HERTFORDSHIRE ECOLOGY

LPA reference: 6/2016/1791/COND

Proposal: Approval of details reserved by condition 4 (Hard and Soft Landscaping) and condition 7 (Access and Parking) on planning permission N6/2014/2504/FP

Location: 52 Bridge Road, Welwyn Garden City, AL8 6UR

52 -54 BRIDGE RD, WELWYN GARDEN CITY
PROPOSED LANDSCAPE PLAN - Sheet 2 of 2

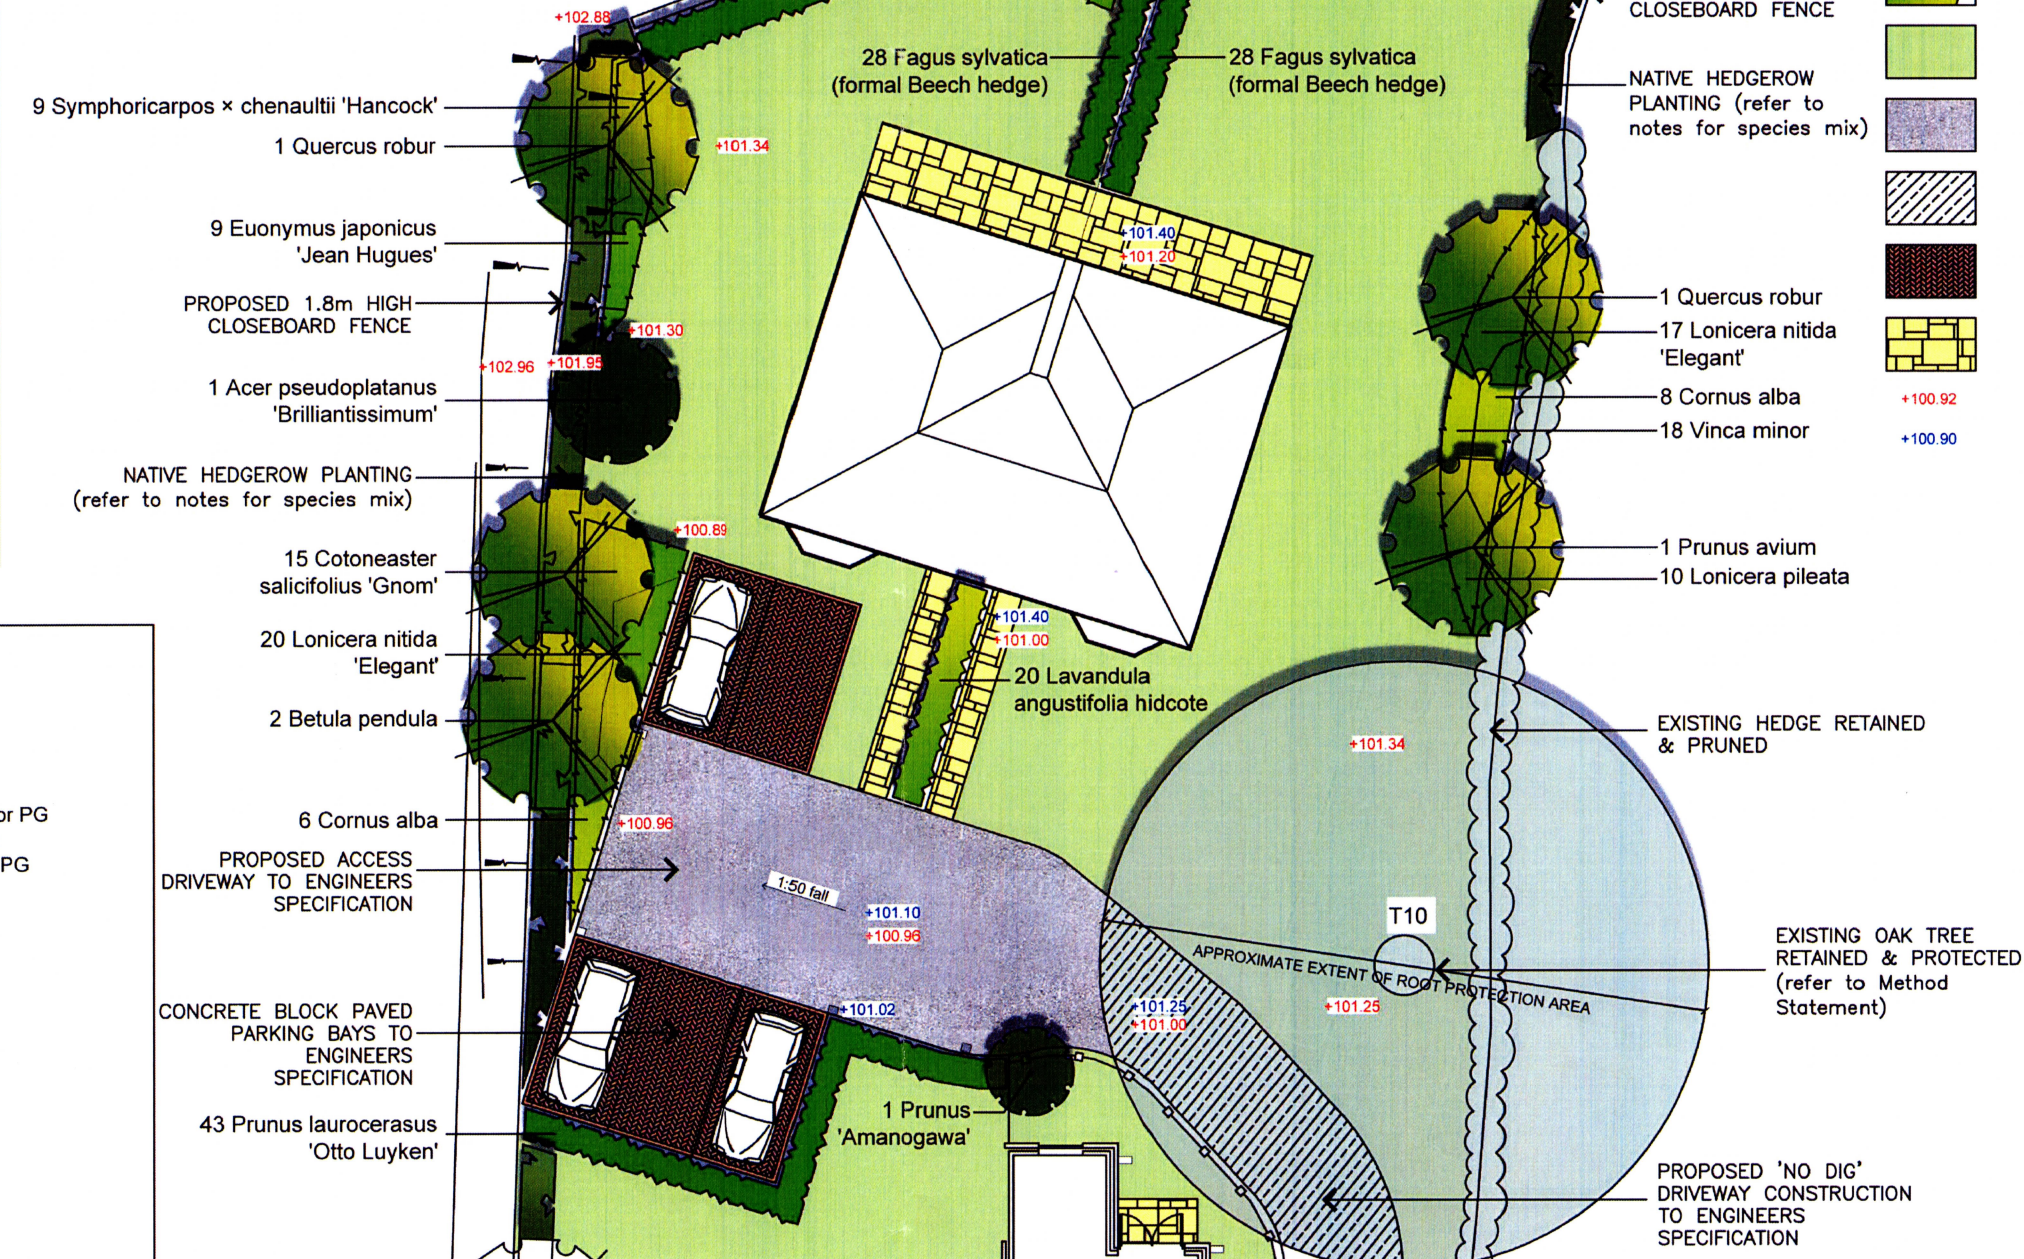
The submitted landscape plans have, to the best of my assessment, provided these details. The planting scheme also required to enhance the value of the development for biodiversity and wildlife. I believe this has been achieved through the use of native plants on a majority of the site including the hedges to be retained and created.

I therefore believe that Condition 4 can be discharged.
